Recommendation Report for Planning Permission for Works or Extension to a Dwelling

REF NO: Y/134/21/HH

LOCATION: 3 Cherry Avenue
Yapton
BN18 0LB

PROPOSAL: Single storey, part two storey rear extension.

Rev	By	Date	Note
Client			
Mr M. Hazelgrove			
Job			
No 3 Cherry Avenue, Yapton, West Sussex. BN18 0LB			
Drawing			
Proposed Alterations and Extension Proposed Plans			
Date			
August 2021			
Scale			
1:100 at A3			
Drawn By			
L.O.			
Dwg. No.			
020721 / SL-30

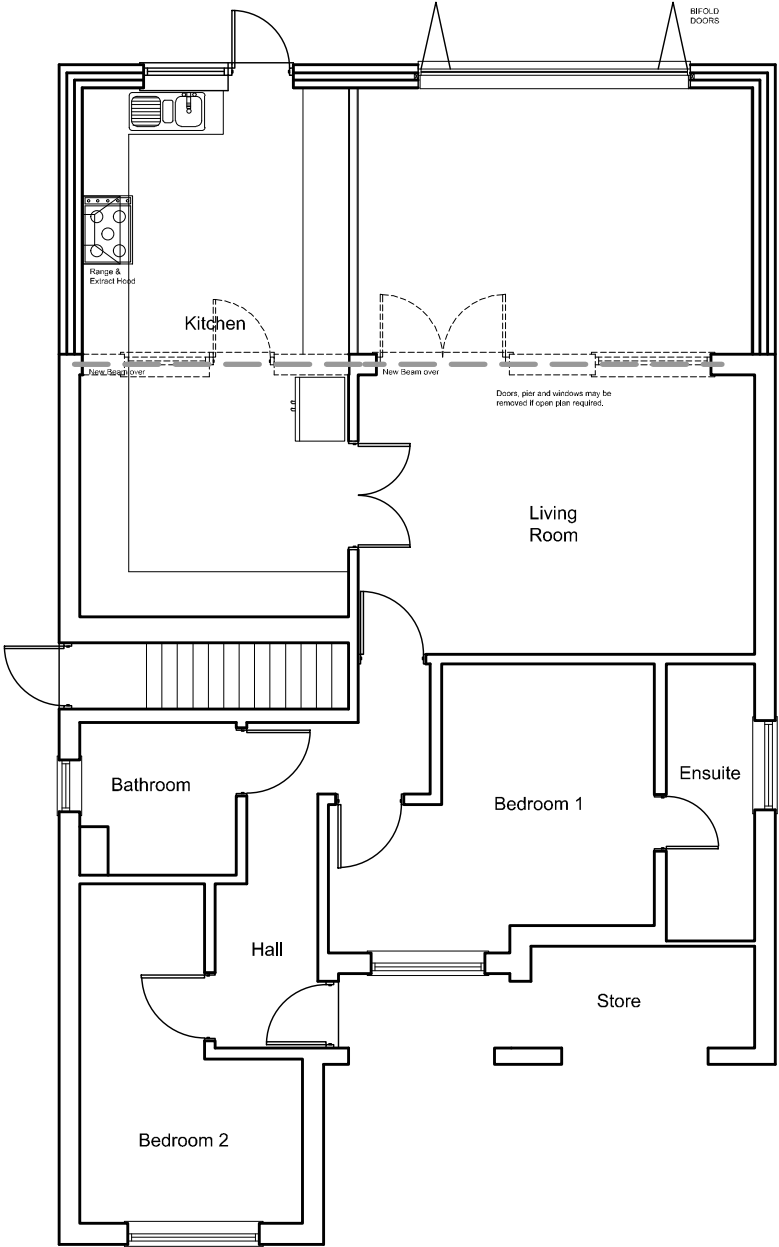
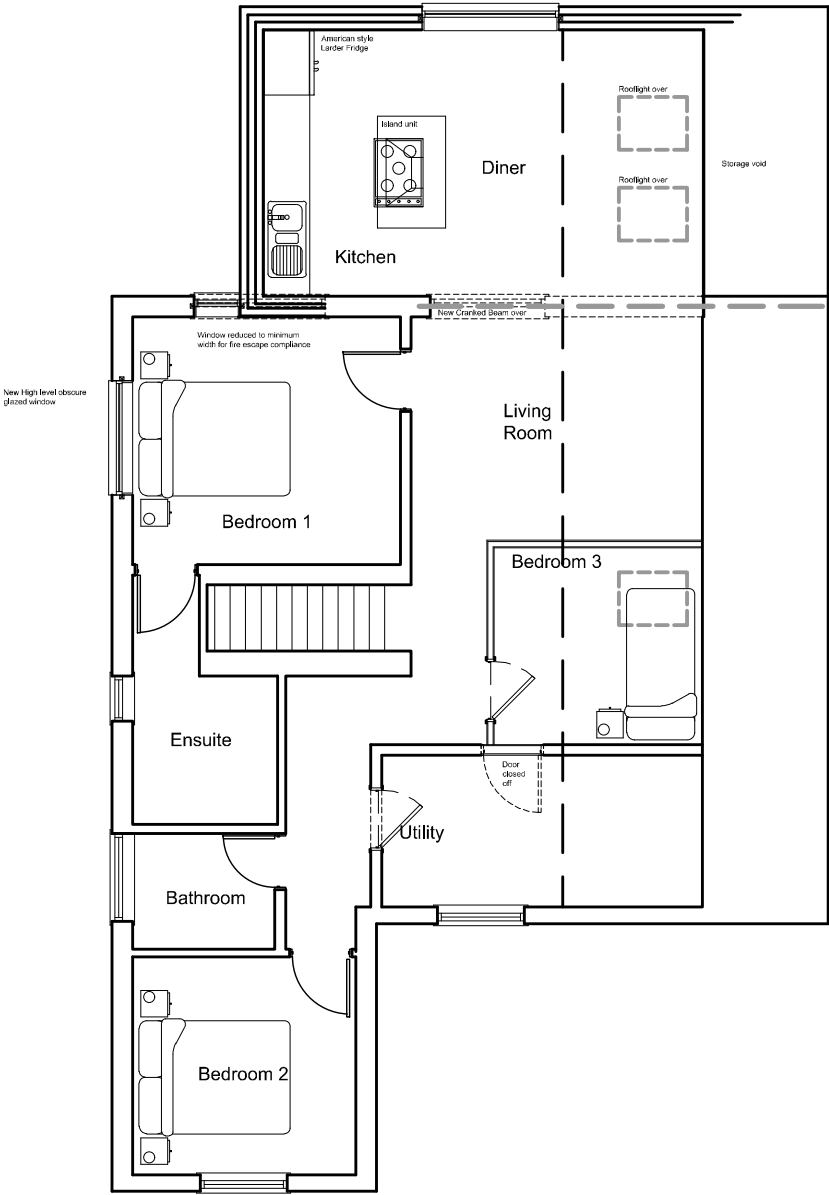
The extension will have a depth of 4m and run along the full rear elevation. This will consist of around 7.7m at two storey and 1.75m at single storey.

There will be an additional window to the first floor south western side elevation. This will serve a bedroom. This does have potential for overlooking upon the garden of No.1 although the plan demonstrates this will be at a high level and obscured glazed to ensure no overlooking views are available. There will also be a first floor window to the rear elevation. With 16m retained to the rear

Rev	By	Date	Note
Client			
Mr M. Hazelgrove			
Job			
No 3 Cherry Avenue, Yapton, West Sussex. BN18 0LB			
Drawing			
Proposed Alterations and Extension Proposed Elevations			
Date			
August 2021			
Scale			
1:100 at A3			
Drawn By			
L.O.			
Dwg. No.			
020721 / SL-31 B

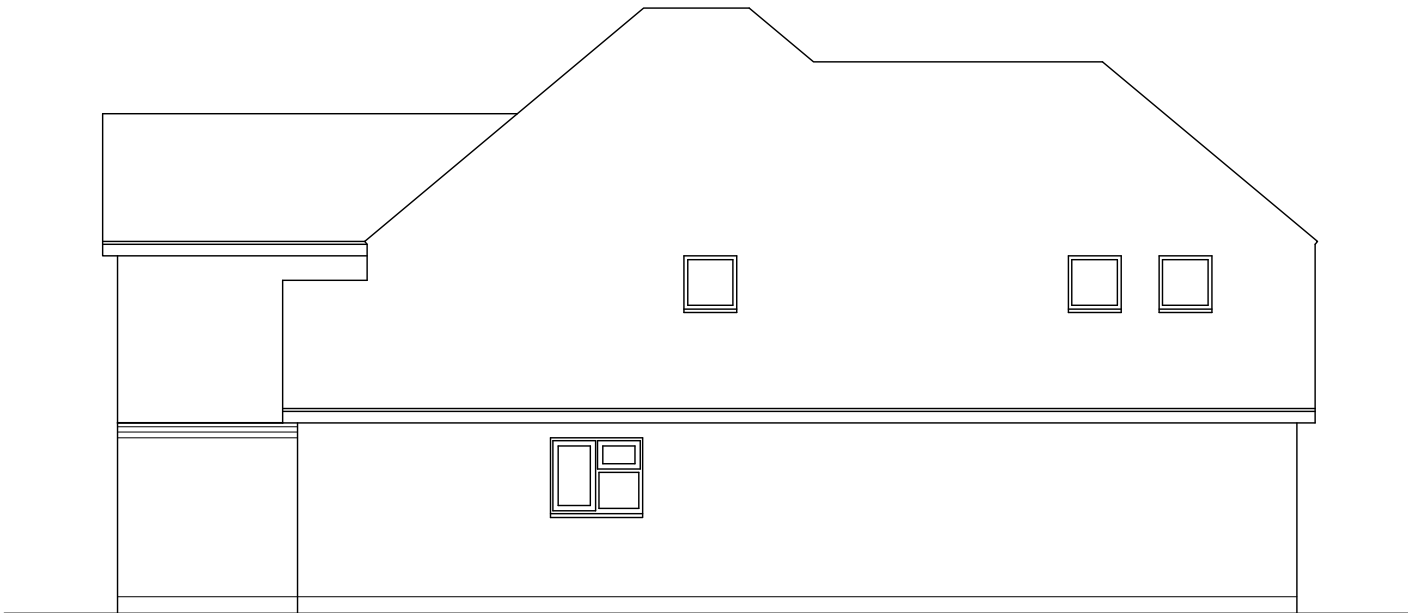
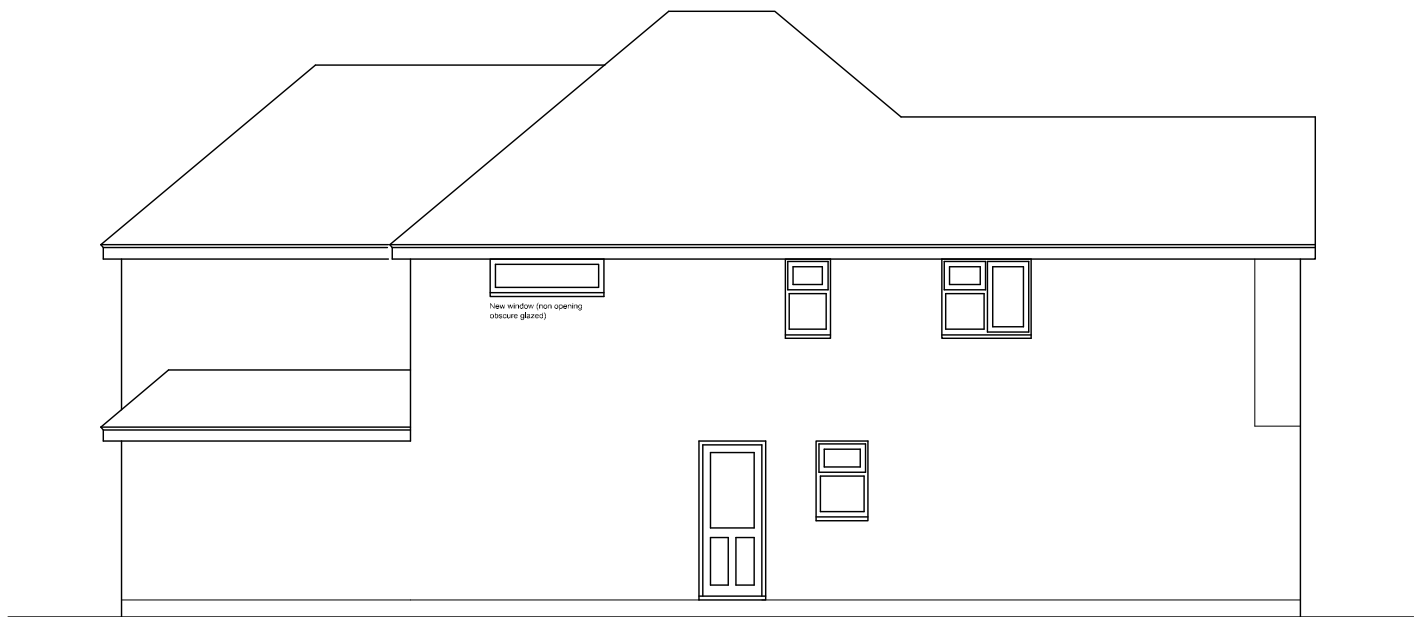
The extension is well integrated and sympathetic in design to the dwelling, matching the roof design which features a cat slide roof to the south western side. The eaves match that of the host dwelling although the ridge will be set below that of the main dwelling and as such it appears a subservient addition.

Due to the siting of the neighbour to the north east at No.5, this will likely have views of the extension however with a cat slide roof to the northern side, the height of the extension is set lower and will extend in line with the host dwelling forming a hip. This is set in from the boundary by 4.1m and due to its design and location it will not result in adverse overbearing or overshadowing.

The dwelling and extension runs in line with the southern boundary, although the extension will reduce to single storey to this elevation with a maximum height of 3.2m. There is sufficient boundary treatment to this elevation featuring fencing and hedging to around 3m in height. As a result the extension will not be visible from the neighbouring side and will not result in adverse harm.

- 3 The first floor window on the south western elevation of the building shall at all times be glazed with obscured glass and only openable at a high level, at least 1.7m above finished floor level.
